RE: Goodwill Bluewater – Erosion & Sediment Control Plan

Below are my responses to the Erosion & Sediment Control Plan Review dated October 18, 2024.

**RE: Goodwill at 270 98<sup>th</sup> St NW  
Erosion and Sediment Control Plan  
Engineer's Stamp Date 9/13/24 (K09E048E)**

C-6.1

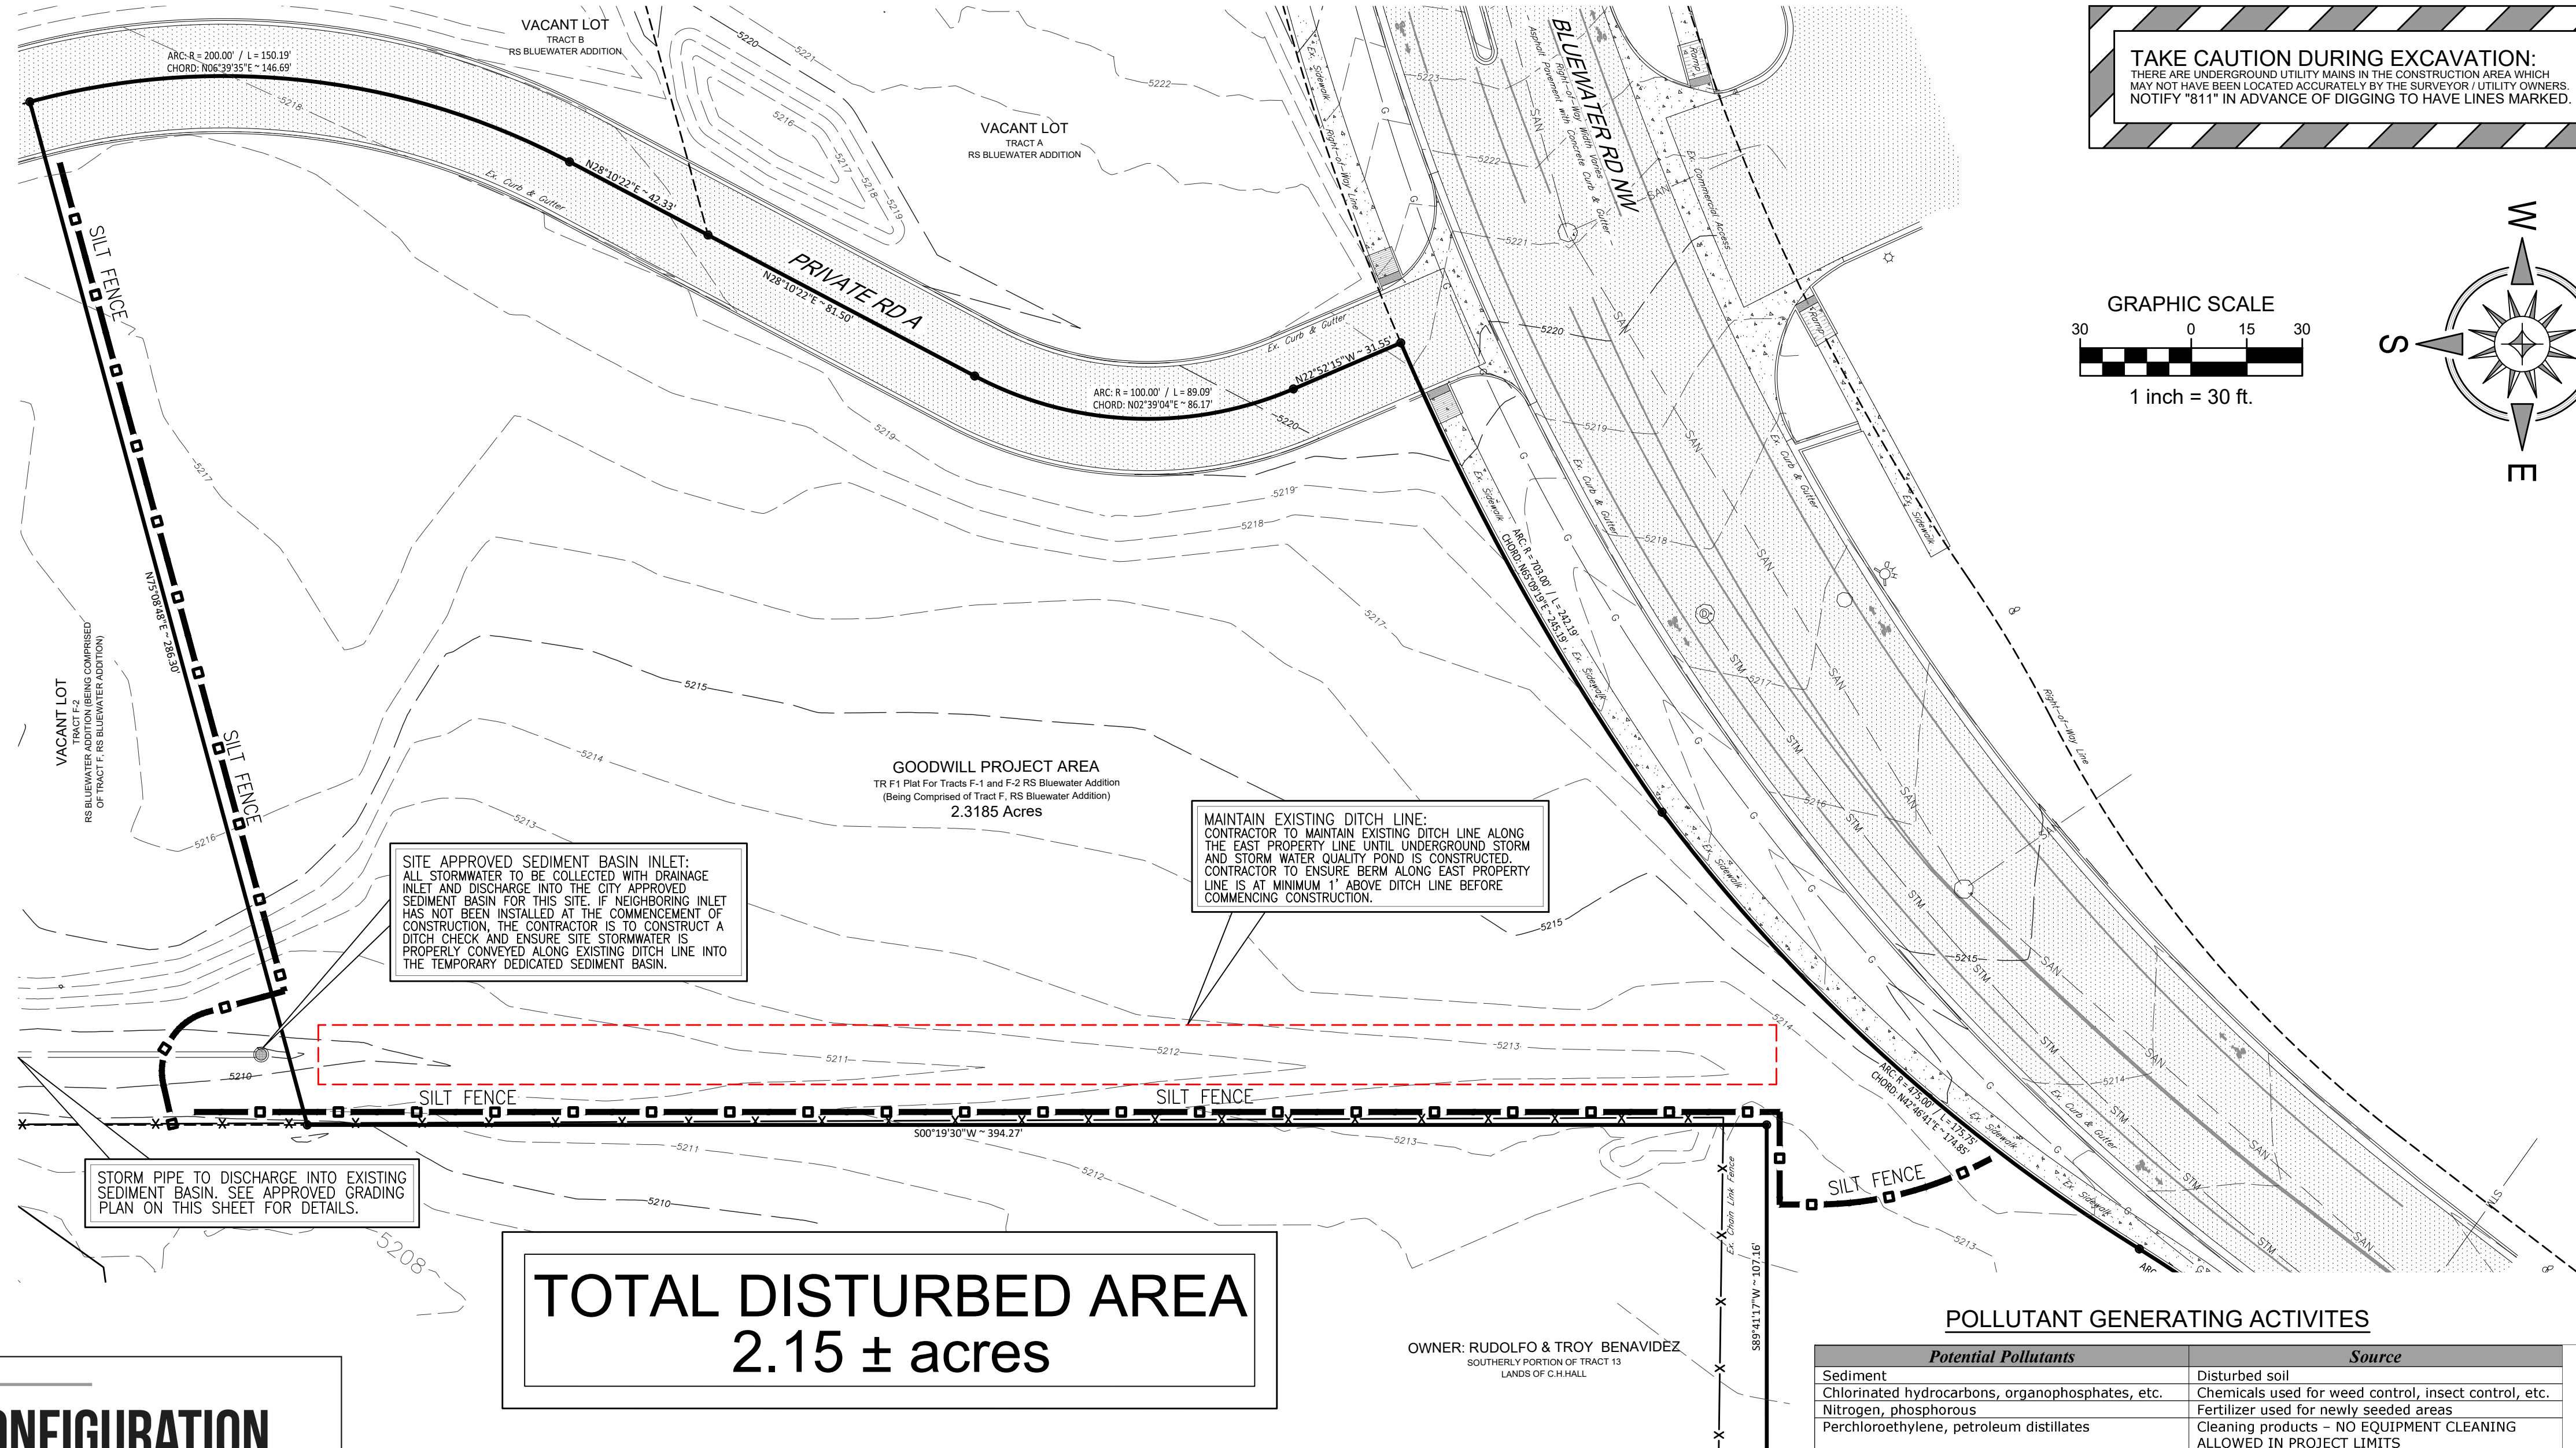
1. This site's only allowed stormwater discharge location is concentrated flow from the southeast corner. Silt Fence (SF) isn't adequate for concentrated flow, so you must provide diversion berms/swales (DV) along the low edges of the site to direct stormwater into a Sediment Basin (SB) or Sediment Trap (ST) per CGP 2.2.12 in addition to the SF.

1. Sheet C-6.1 now shows the concentrated stormwater at the Southeast corner of the site being collected with an inlet where it will discharge into the approved sediment control basin for the site per the approved grading plan dated 4/18/22 (K09D048). The existing ditch line and berm along the east property line is noted to be maintained throughout construction until the permanent underground storm piping and SWQ basin are installed (details on sheet C-6.0).
